Recommendation Report for Planning Permission for Works or Extension to a Dwelling

REF NO: R/270/19/HH

LOCATION: 1 Pigeonhouse Lane
Rustington
BN16 2AY

PROPOSAL: Ground and first floor rear extensions - resubmission of R/197/18/HH

Drawing Title: PROPOSED ELEVATIONS

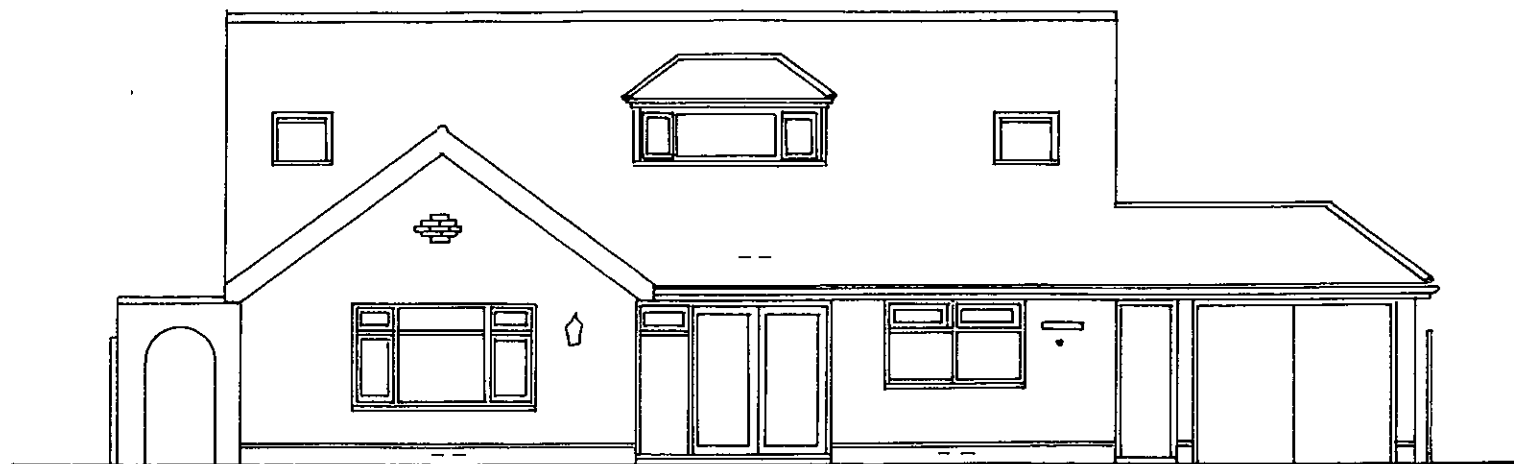
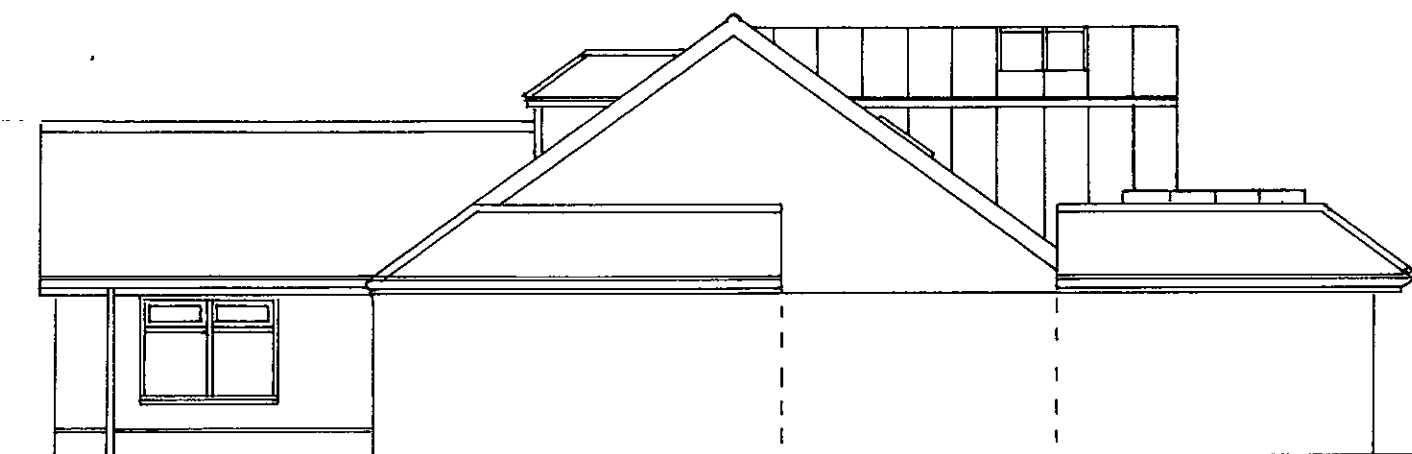
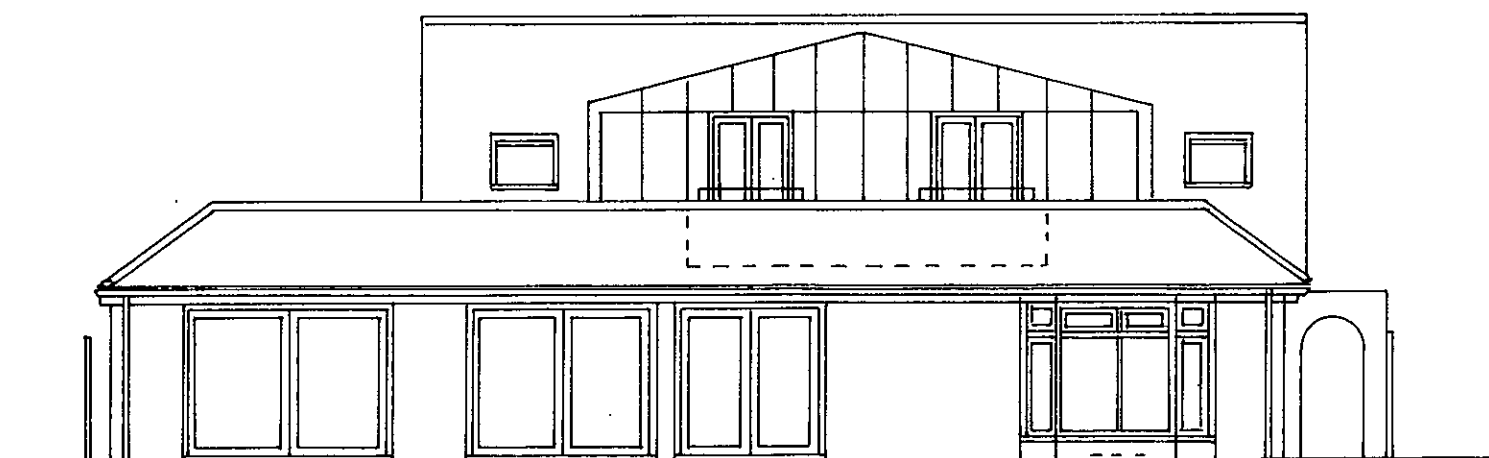
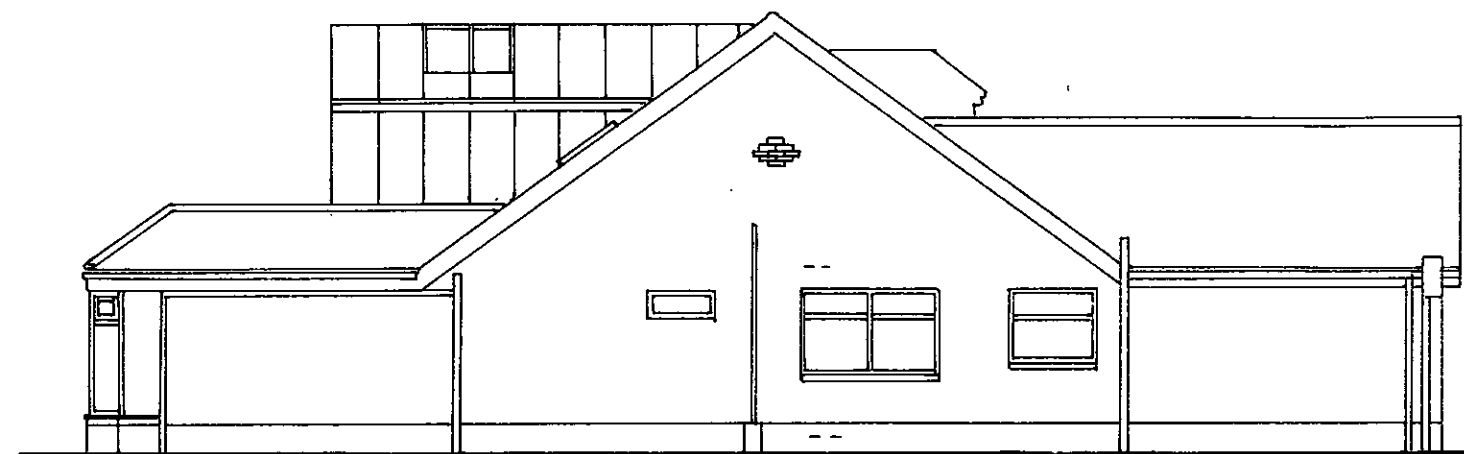
The proposed change of roof tiles from the existing brown tiles, to slate tiles is not considered to result in any significantly harmful impact upon the character of the area. This is due to the presence of this material within the area already, on properties to the North, and North-East of the application site.

The proposed development is not considered to result in a significant loss of privacy to occupiers of adjacent dwellings. The windows proposed on the Eastern and Western elevations of the dwelling offer only oblique and acceptable views of neighbouring properties. These views are not considered to be harmfully materially different to those currently available. With regard to the rooflights, it is noted that there are concerns that there could possibly be, from an open window, harmful views towards neighbouring dwellings that would lead to a loss of privacy. However, these are considered to be available on a very infrequent basis and not so as to warrant a refusal of permission.

Drawing Title: PROPOSED FIRST FLOOR PLAN

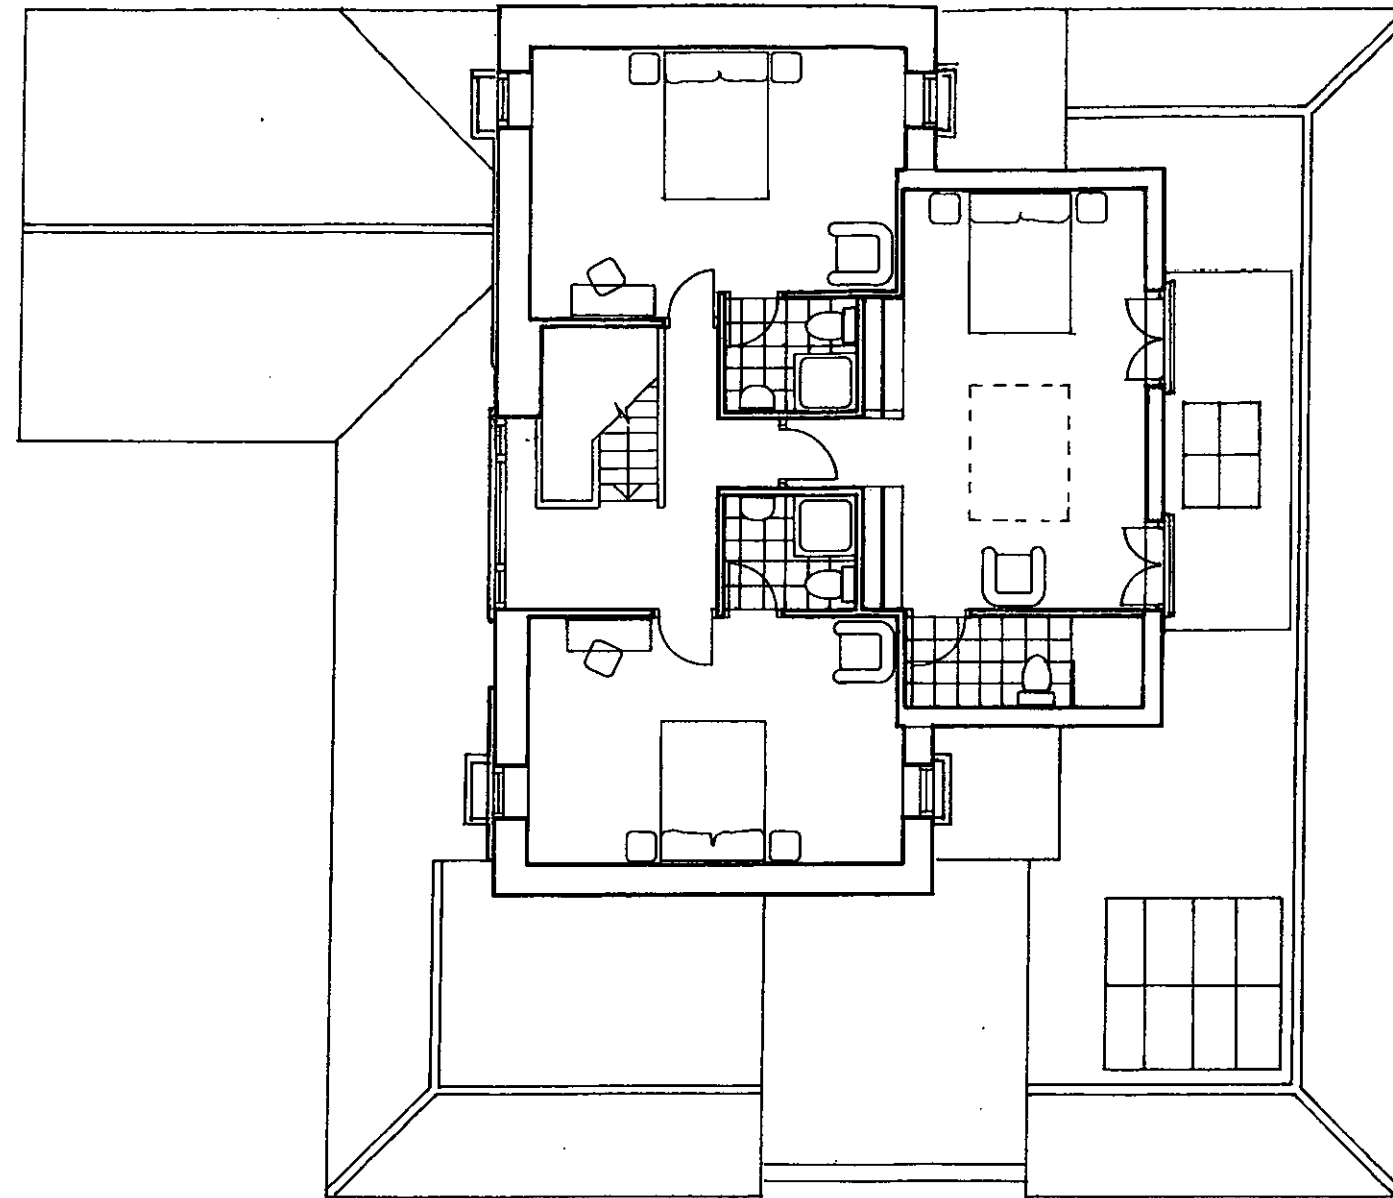
The proposed first floor extension is reduced in scale compared to that previously submitted, including a reduction in depth of approximately 3m. As such, it projects approximately 5.6m from the rear roof slope of the host dwelling, set down 0.2m from its ridge height. Resultant of its reduced scale, and matching materials, the proposal is considered to appear sympathetic to the appearance of the host dwelling, and have no significantly harmful impact upon its character. With regard to its impact upon the locality, it should be noted that this extension will be obscured from the public view, resultant of its siting. Additionally, there are similar extensions within the area, for example, the similarly large box dormer sited on the property to the North, at 9 Cross Road.

The proposed rear first floor extension is not considered to result in any significantly overshadowing, or overbearing impact upon the neighbouring dwellings. This is due to the acceptable scale of the proposal, and its sufficient separation distance from the primary windows of neighbouring dwellings. To the South, there is a distance of over 5m between the first floor extension, and 3 Pigeonhouse Lane.

in this aspect. The first floor extension is set 2m in from the Northern gable end of the host dwellings' roof, which is a further 1.2m away from the Northern boundary of the site. Furthermore, the extension is at its lowest point when this far from the Northern boundary, in that it slopes down 1m from its maximum height to its eaves.

Drawing Title: PROPOSED GROUND FLOOR PLAN

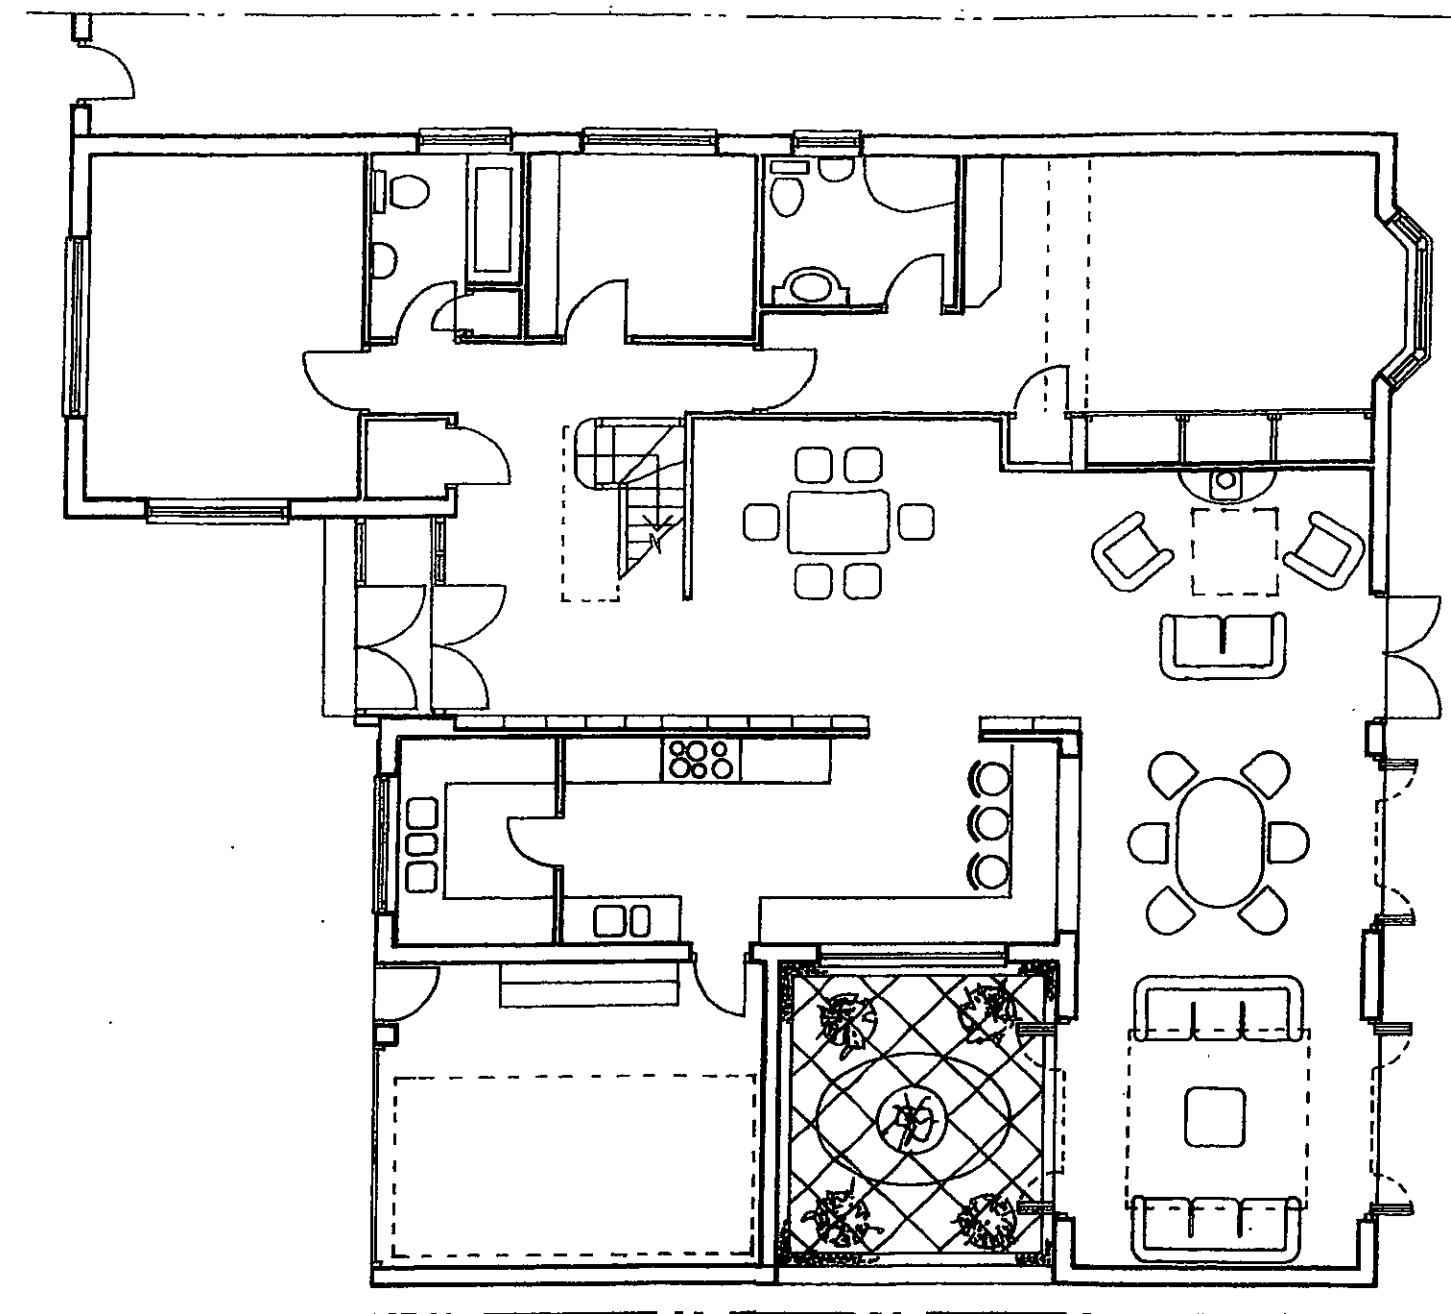
The proposed ground floor rear extension, by virtue of its siting, will not be visible within the street scene. Furthermore, it is considered to represent a subservient and well integrated addition to the host dwelling, as it replaces an existing conservatory, continuing the ridge and eaves height of the existing rear extension.

The rear ground floor extension is not considered to result in any significant impact upon neighbouring dwellings by way of overlooking, overshadowing or overbearing impact. This is resultant of its limited scale and acceptable siting.
